April 2, 2024

Re: **Kendall Auto Group Auto Storage Yard - PA 23020**
IECO No. 20-1092

The project referenced above is revised in response to the review comments dated February 23, 2024. The review comments are numbered on the letter and have been addressed in *italics* as follows:

GENERAL NOTES & DETAILS
SHEET C4.1

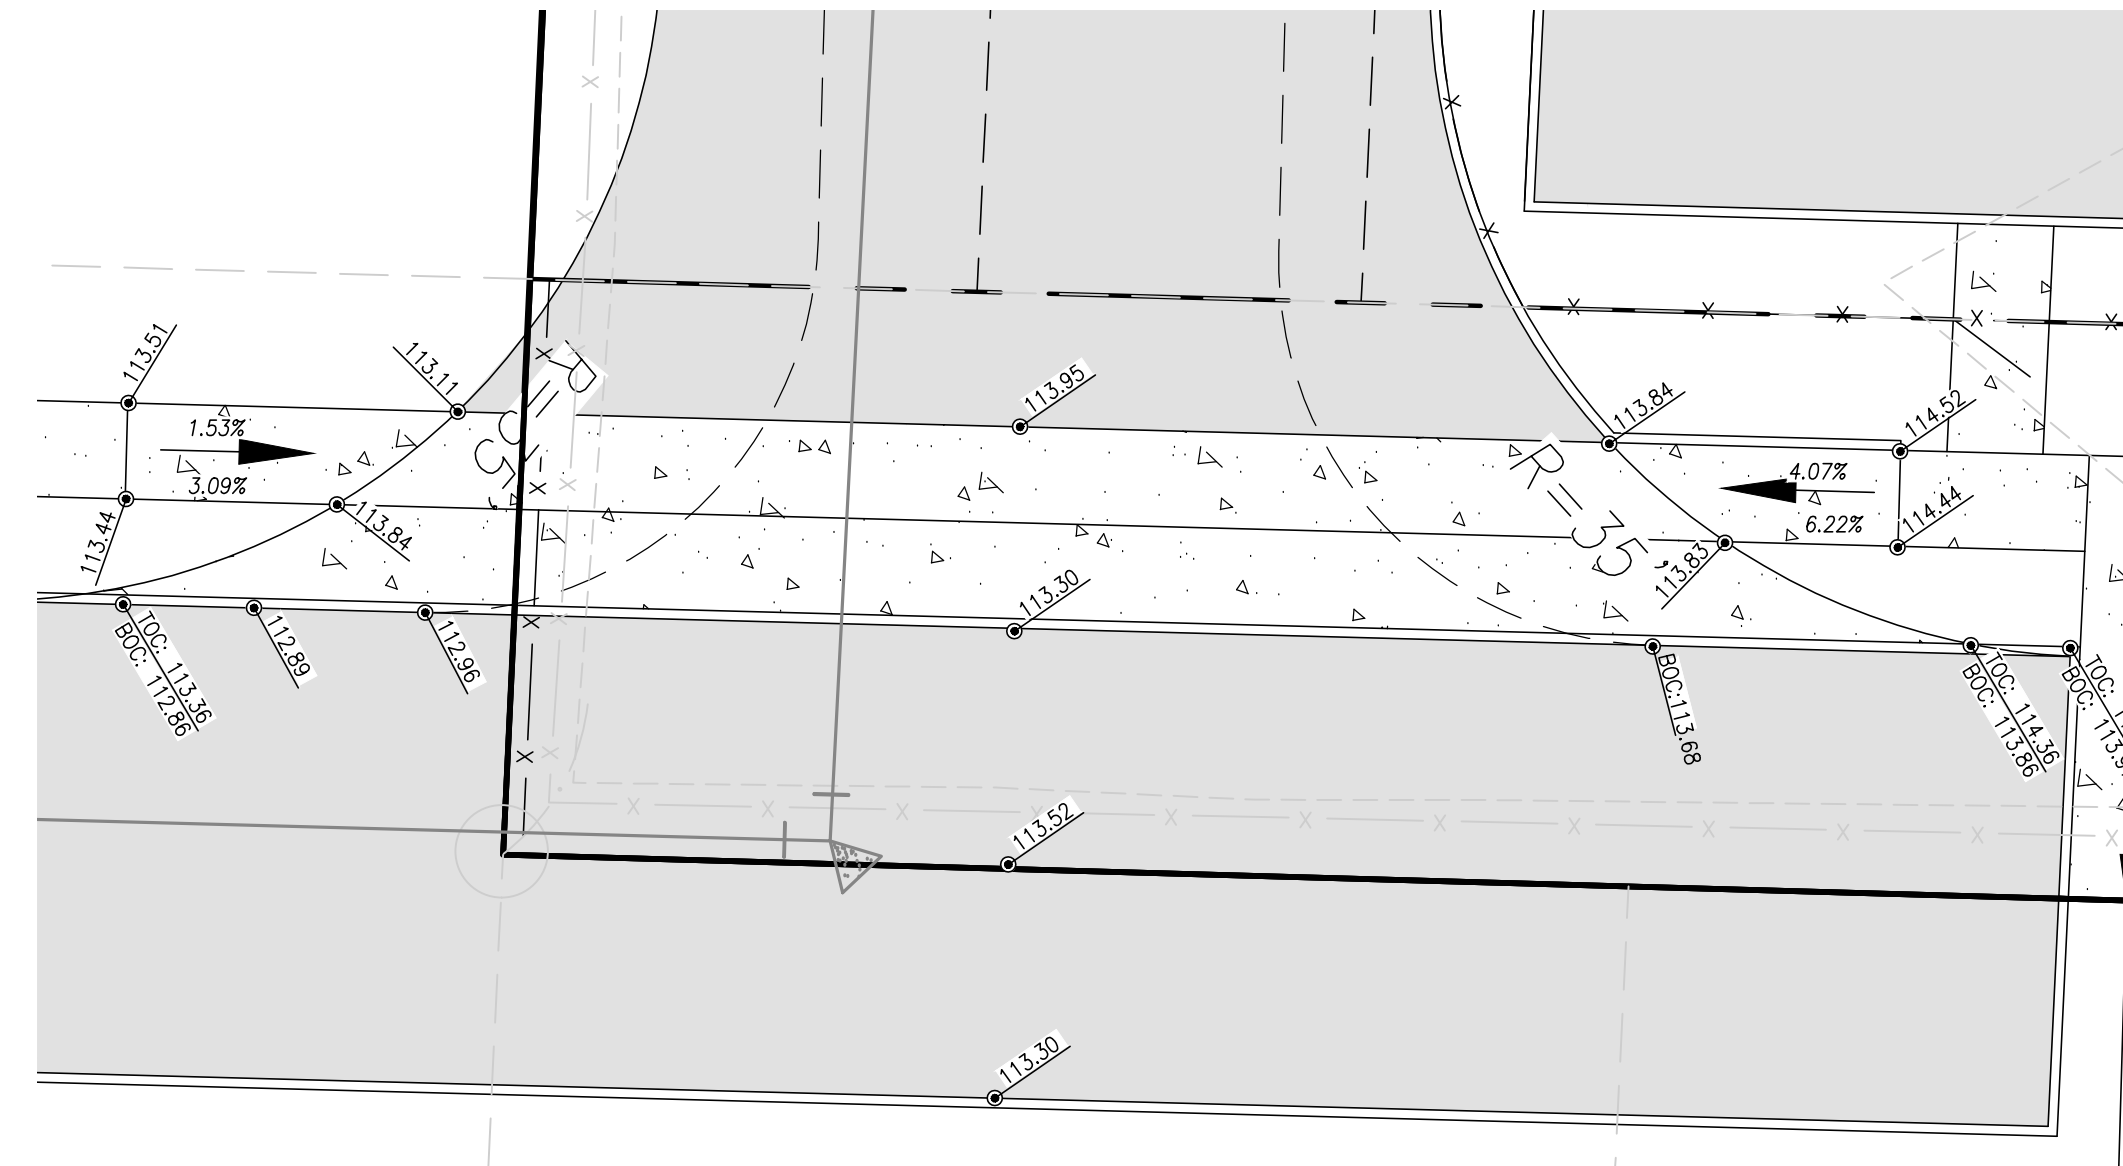
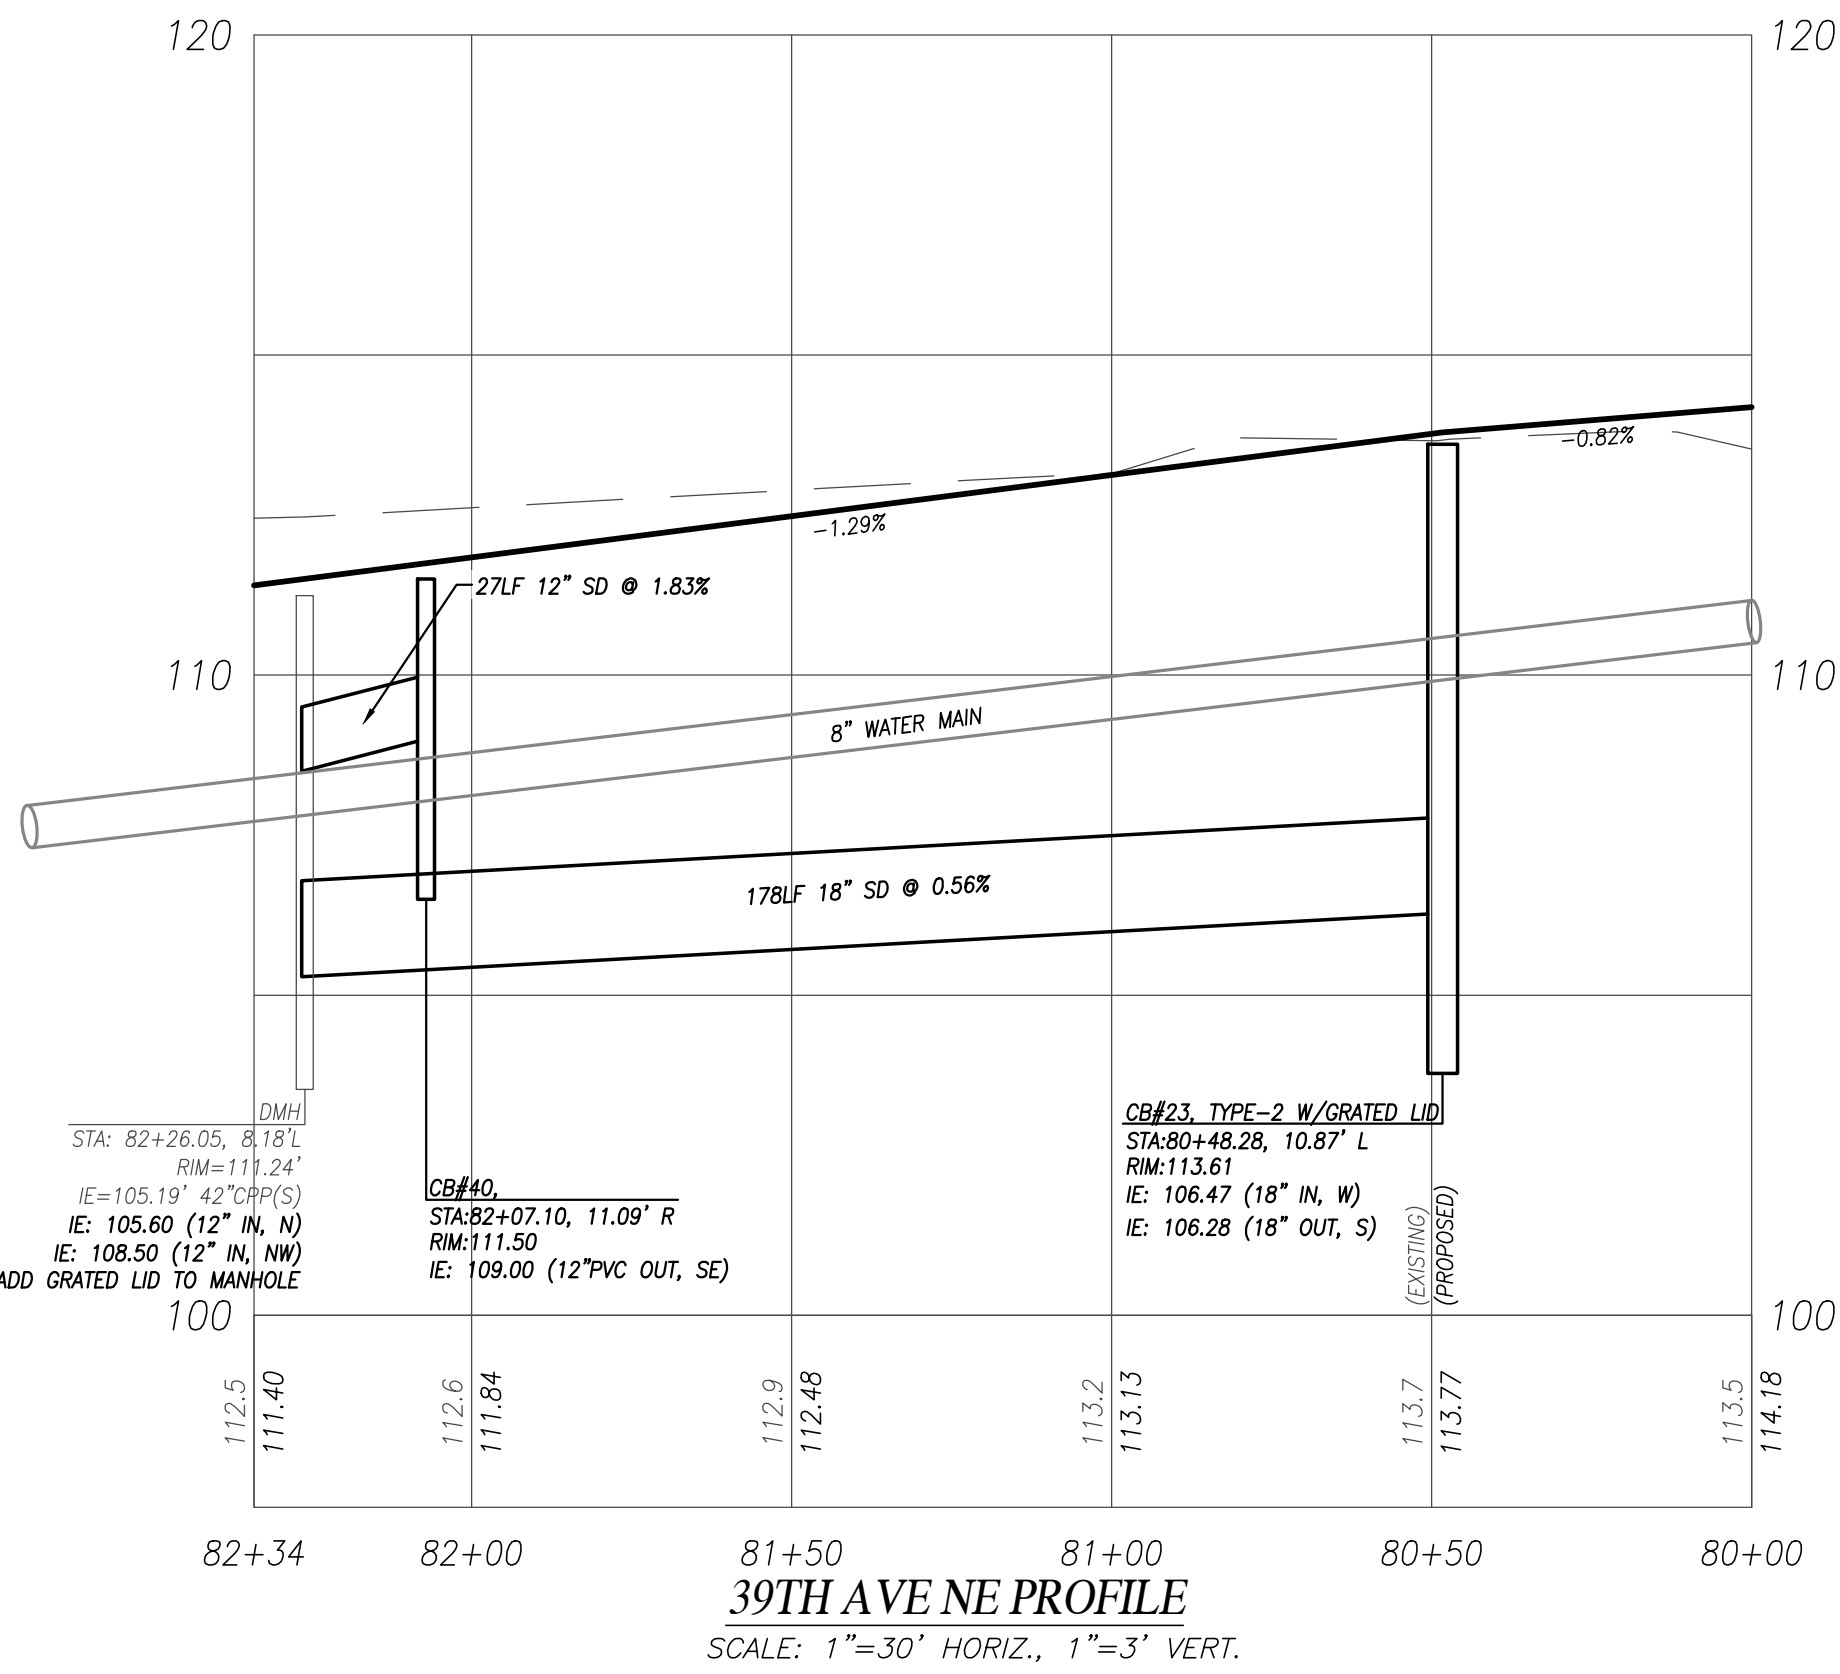
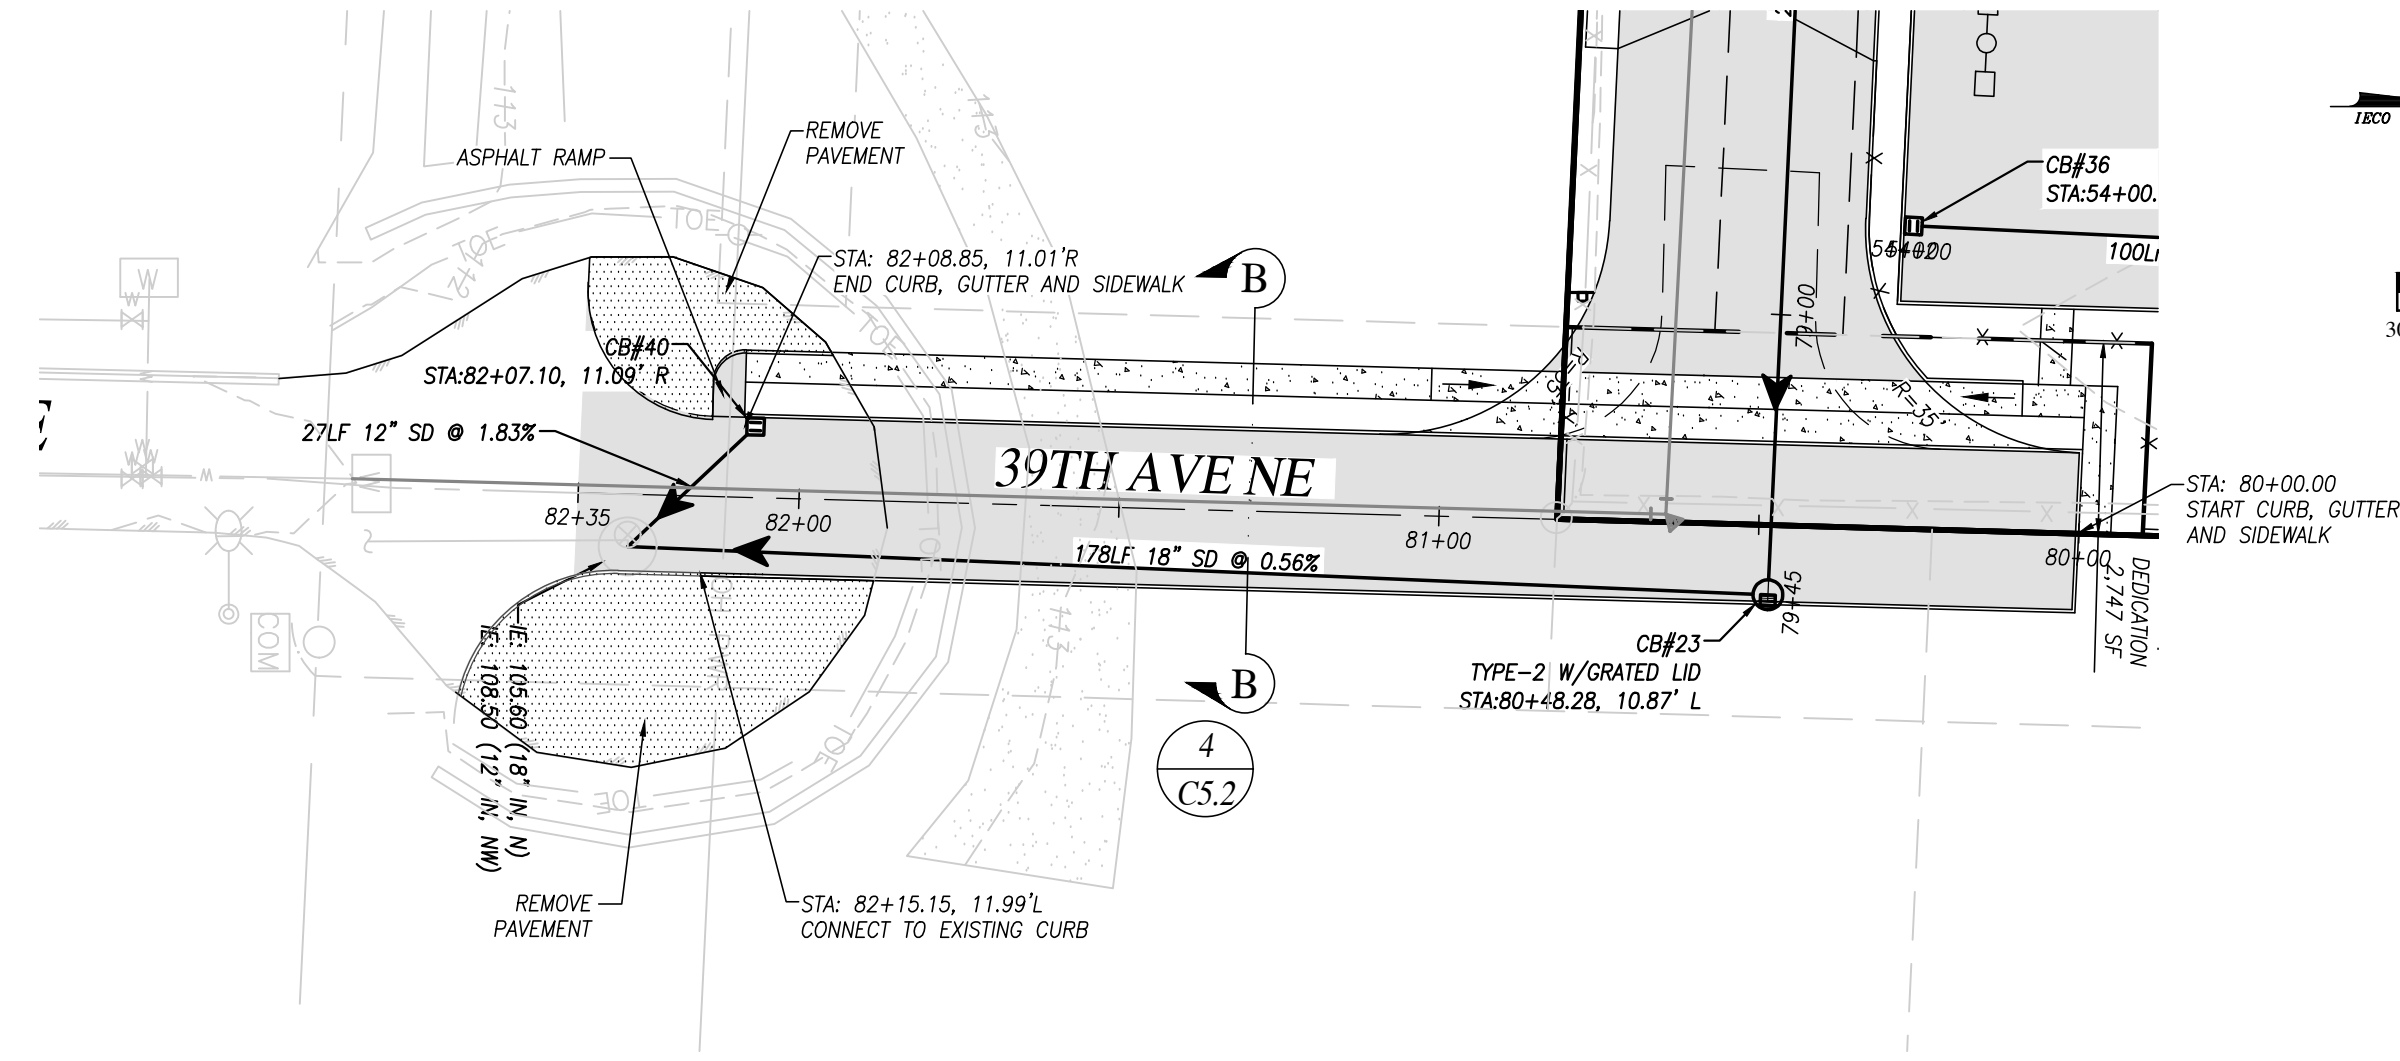
18. Frontage Improvements/Roadway construction shall be required for 39th Ave NE along eastern property line.
- a. Roadway cross-section shall be per EDDS Standard Plan 3-201-003.

The cross section has been revised.

C5.0
SHEET

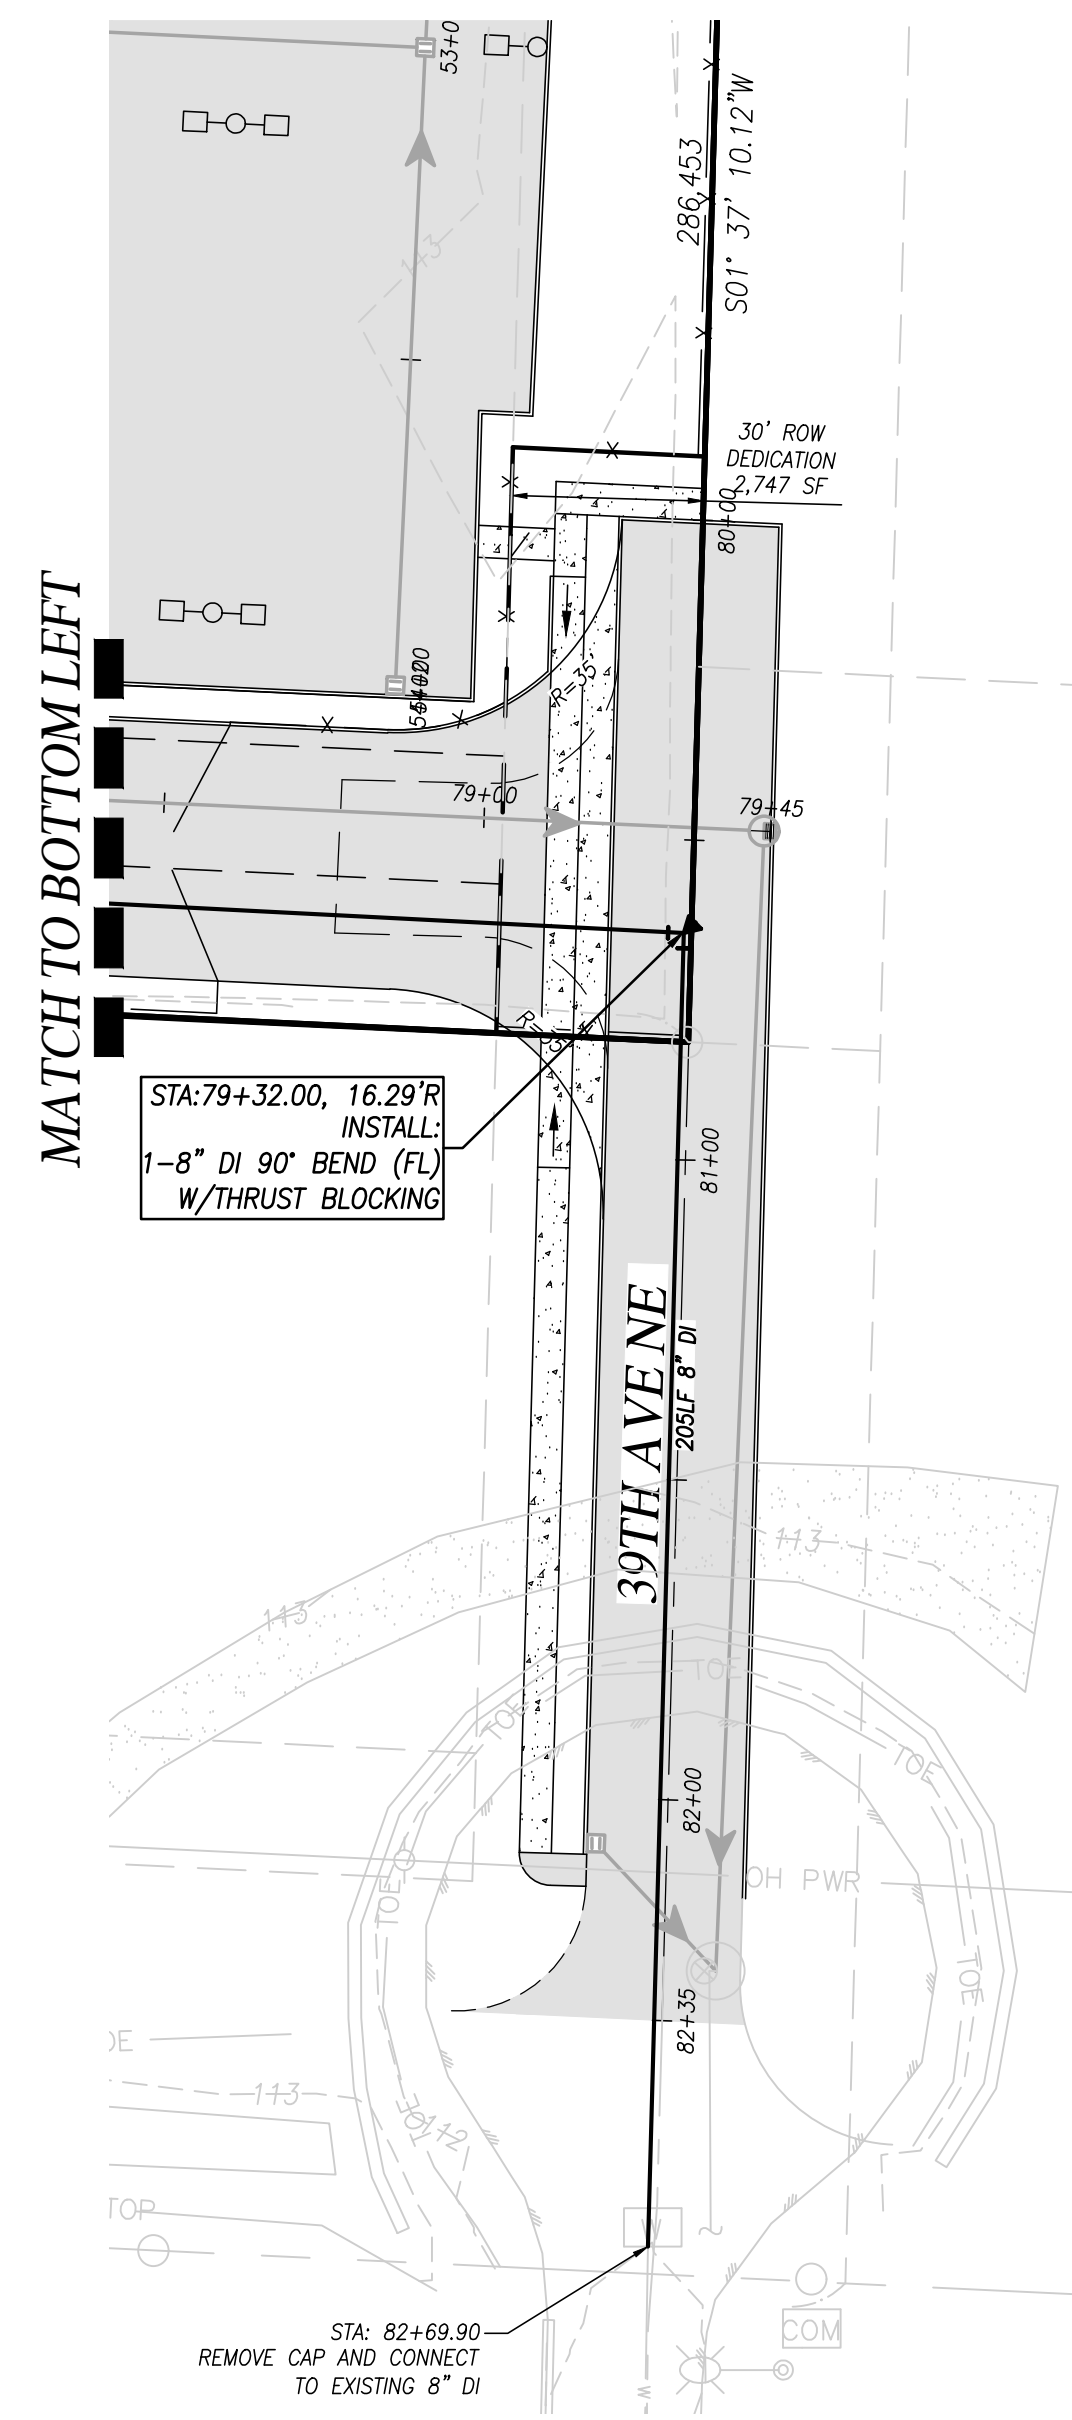
- b. Existing Temporary cul-de-sac at northern terminus of 39th AVE NE shall be removed by development with, at minimum, west side curbing connected into existing curbing just south of temp cul-de-sac.

Please see the callouts on C5.0.
